# KIRKLEES METROPOLITAN COUNCIL INVESTMENT & REGENERATION SERVICE

### DELEGATED DECISION FOR DISCHARGE OF CONDITION A.4 - NOTIFICATION OF A PROPOSED ENLARGEMENT TO DWELLINGHOUSE

Reference no.	2025/HH/91357/E
Site Address	14, Harefield Drive, Birstall, Batley, WF17 0PQ
Description	The proposal is for erection of single storey rear extension. The extension projects 6m beyond the rear wall of the original dwellinghouse. The maximum height of the extension is 4m, the height of the eaves of the extension is 2.92m
Recommending Officer	Molly Storer

Revisions		Planning Application for:	
Date	May 2025	Rear Extension 14 Harefield Drive, Birstall	
		Drawing Title: Existing Plans and Elevations	
		Drawing No: S01	Rev
		Scale: As shown	Paper Size: A0

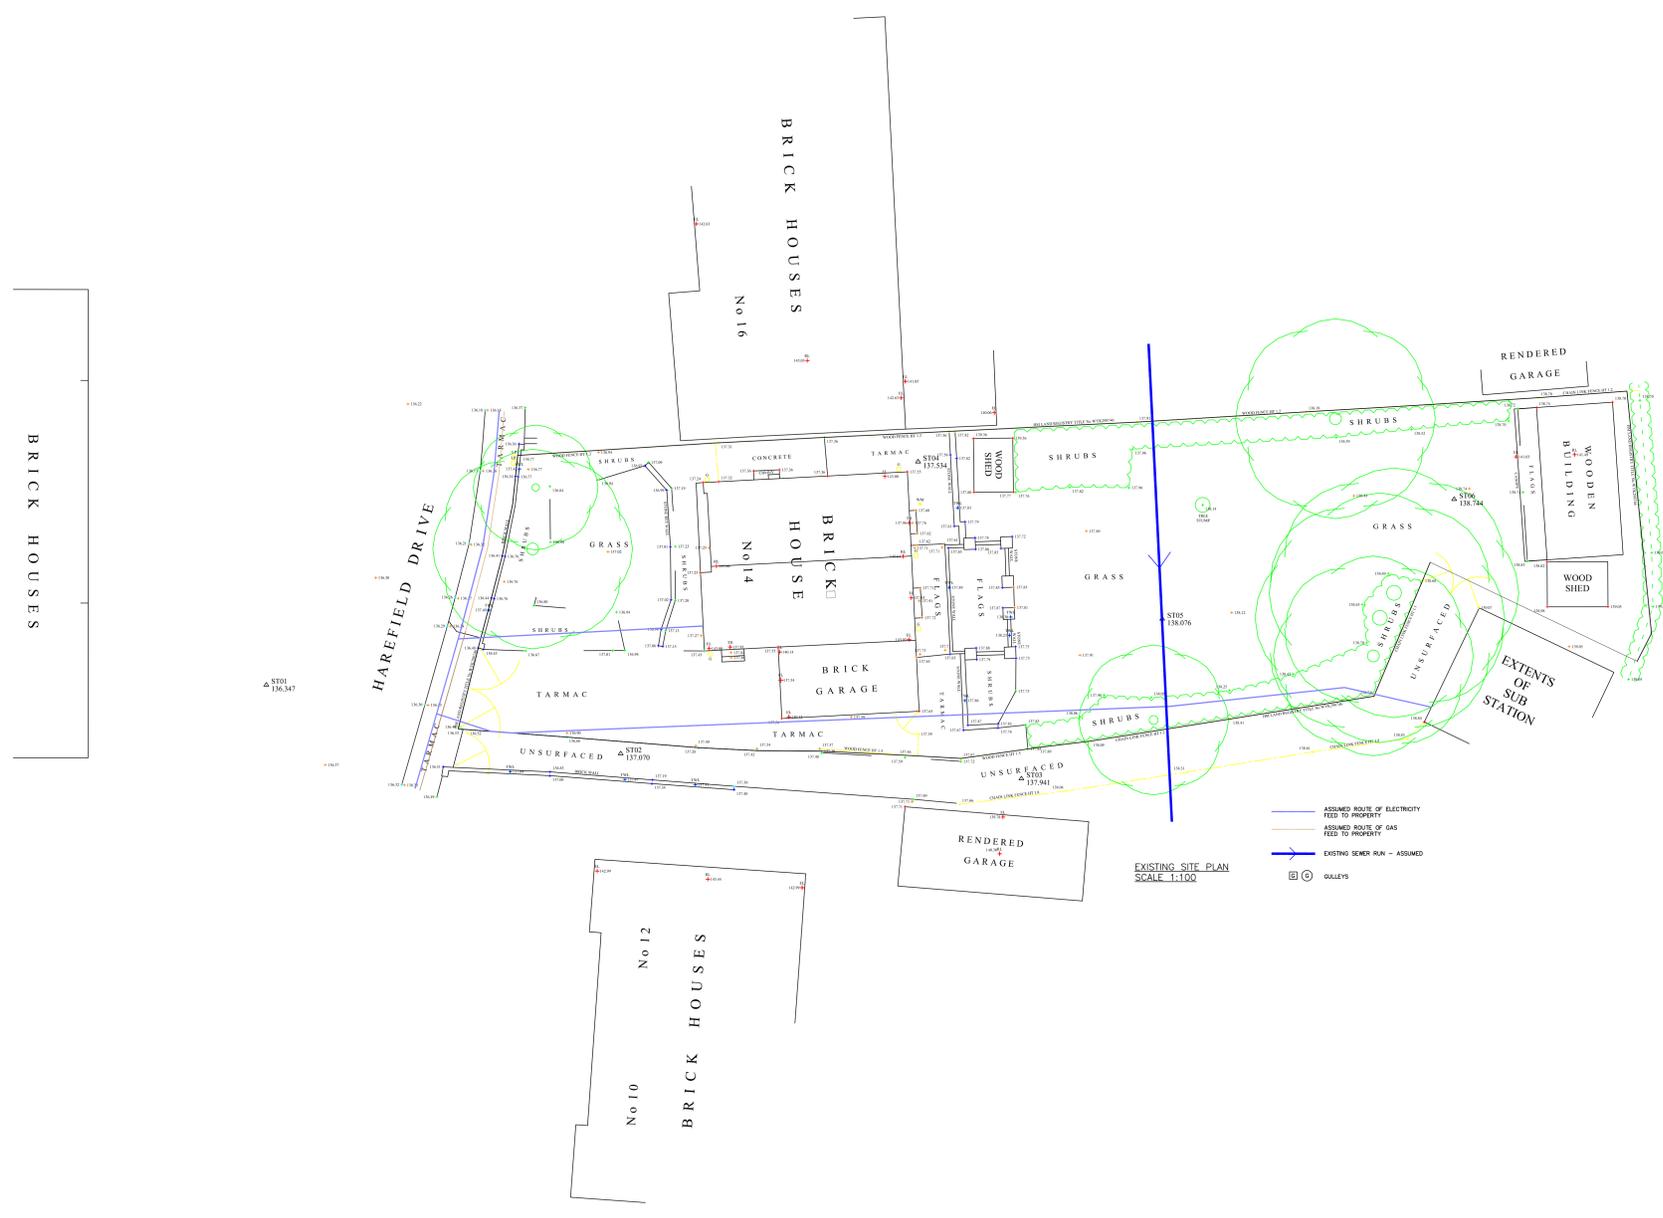
16 Harefield Drive is a two-storey semidetached dwelling to the north of the application dwelling. The proposed development would be single storey and would project 6.00m from the rear elevation of the applicant property. It appears from the property's planning history and aerial imagery that this property has been extended to the rear by 2.75m and to the side boundary with the applicant property.

Drawing No.S03 shows that there will be a new brick wall constructed to the top of the existing garage rear wall from which part of the extension will project from. Therefore, the extension will partly project from a wall that is not original to the dwellinghouse . Having regard to the Government's householder guide to permitted development rights (2019) and sub-paragraph A.1(j), Class A, Part 1 of Schedule 2 of the Town and Country Planning(General Permitted Development)(England) Order 2015 (as amended) development is not permitted under Class A where the proposed extension extends beyond an elevation which is not original to the dwellinghouse.
